14 December 2015

File Number: 2015/658785  
Our Ref: R/2015/26/A

**RE: State Significant Development 7133 – Building W1 Student  
Accommodation, Darling Drive Plot, Sydney International Convention,  
Exhibition and Entertainment Precinct**

LANDSCAPE PLAN - NORTH PARK

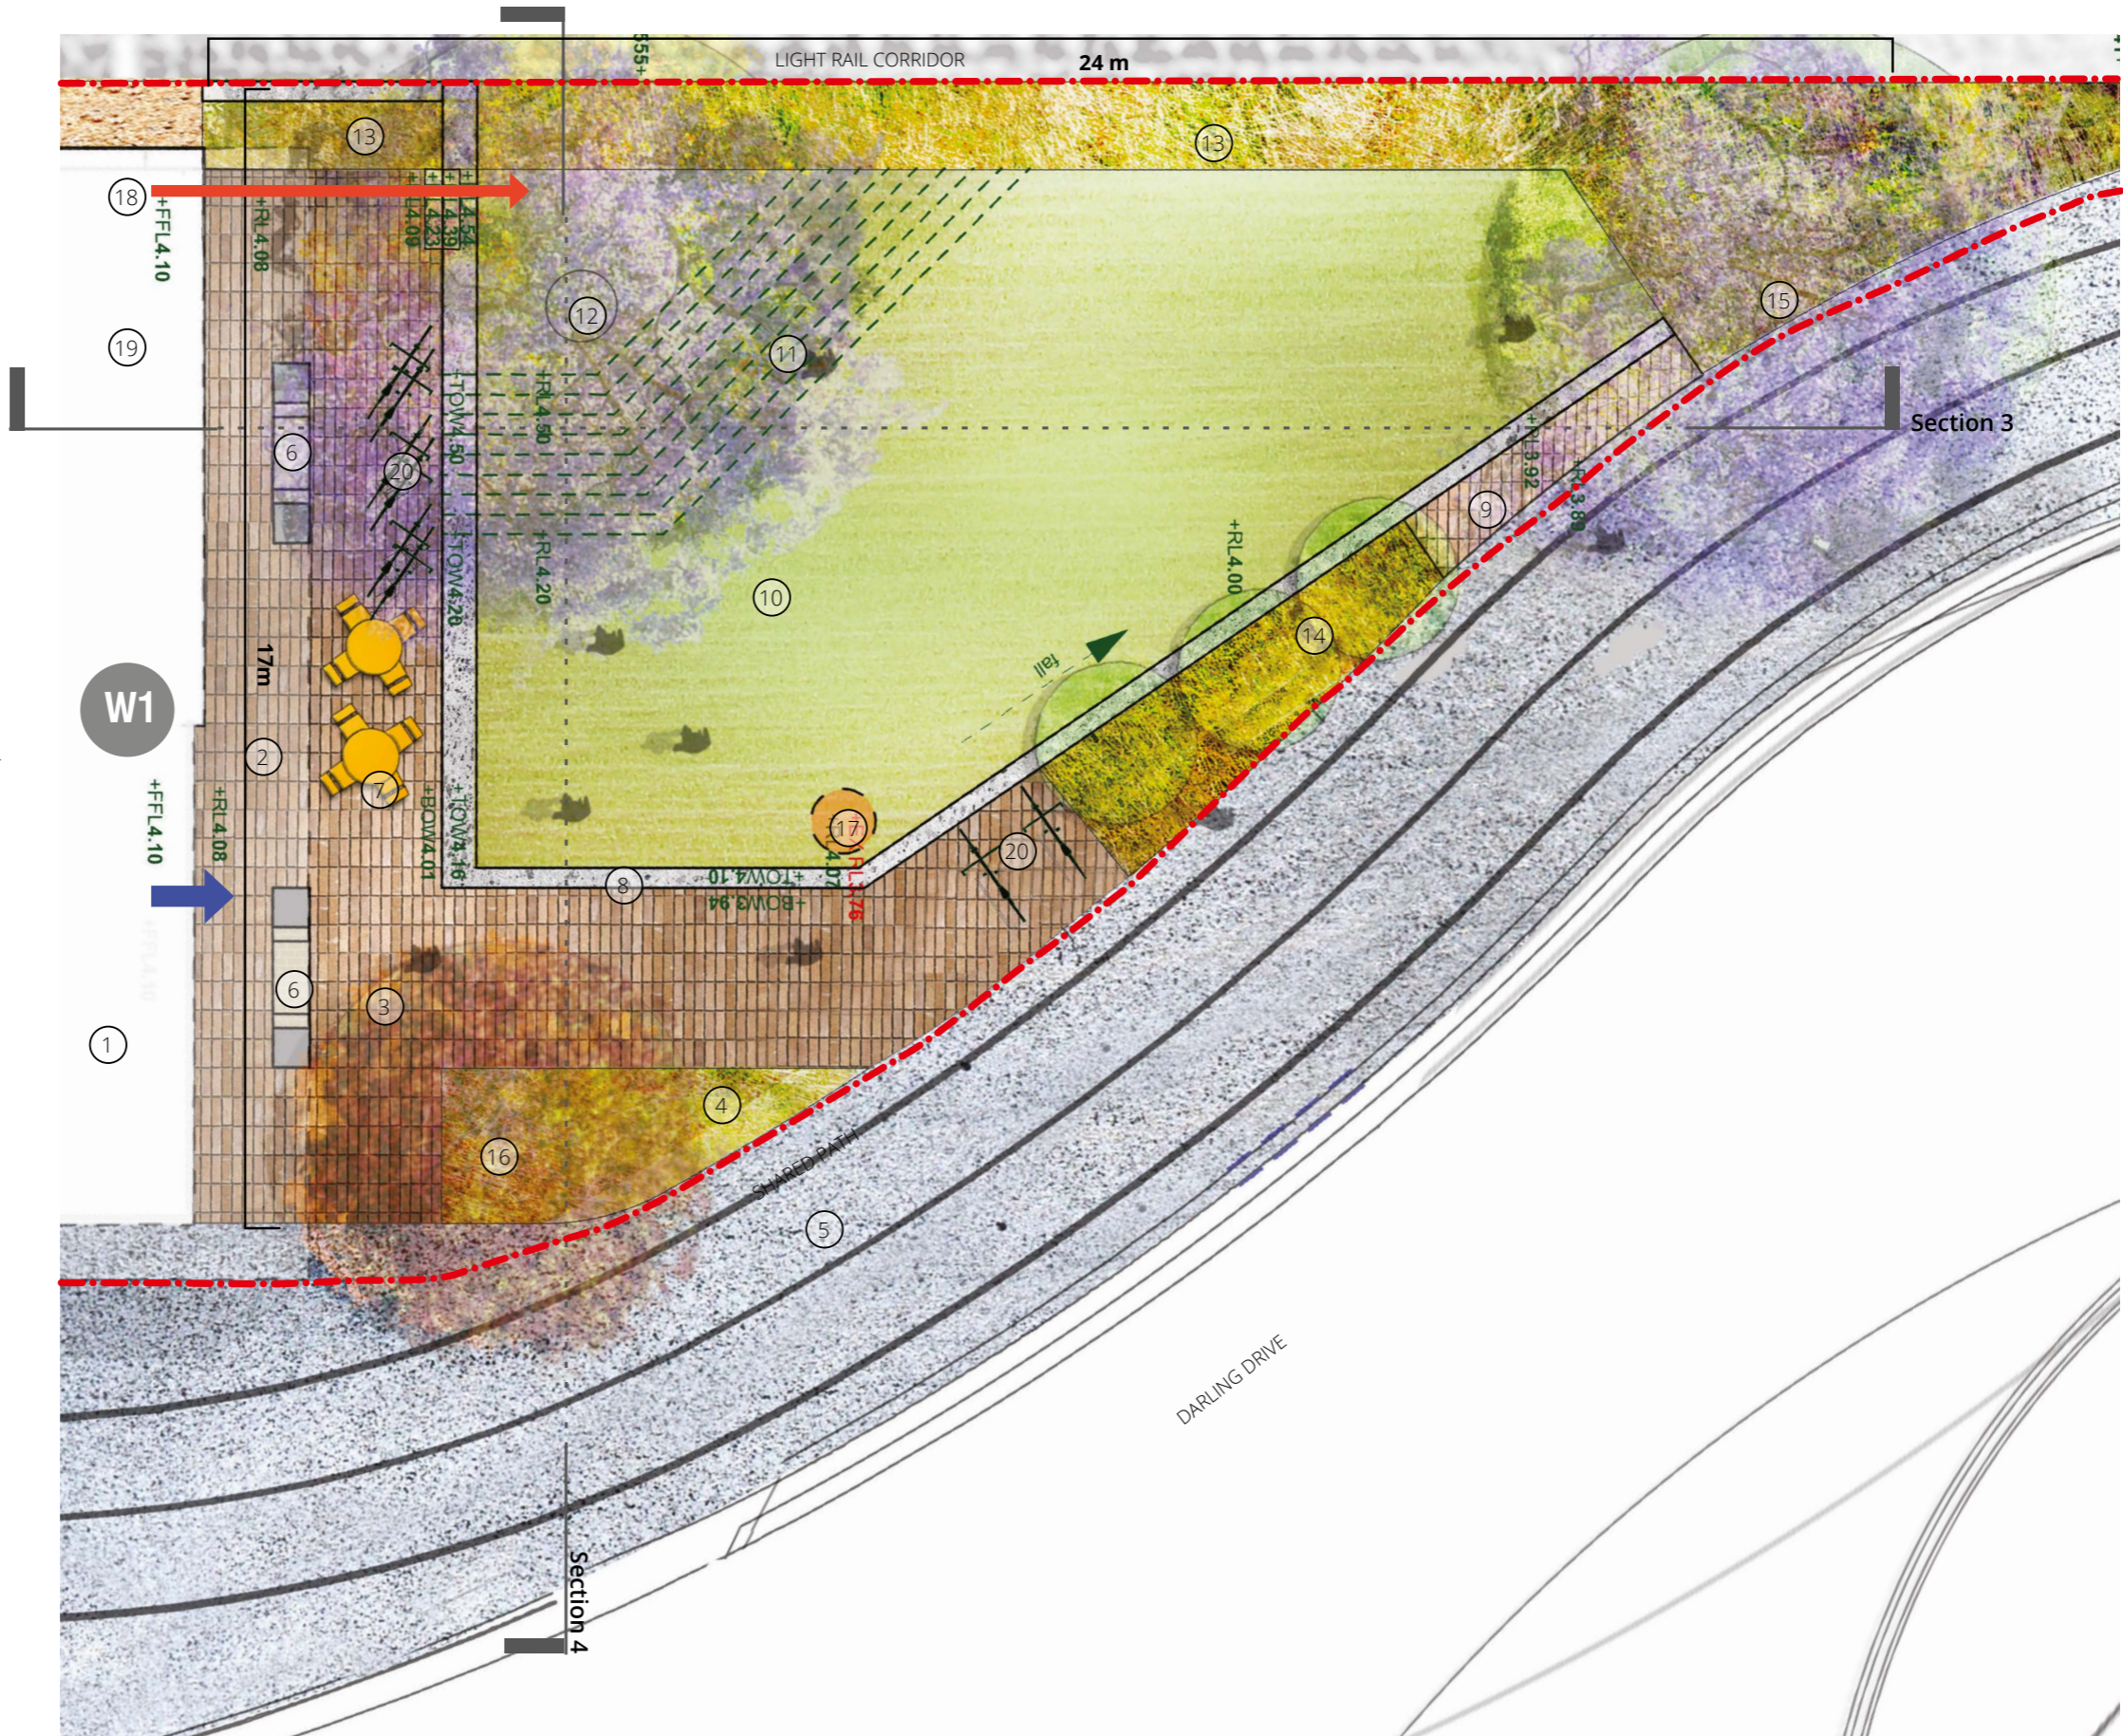
**Boundary to light rail:** The boundary between the central courtyard and light rail should be designed as an element that integrates with the built form, unifying the space. The applicant should consider designing an integrated element connecting the two buildings and forming the boundary to the light rail, removing the need for the chainlink fence.
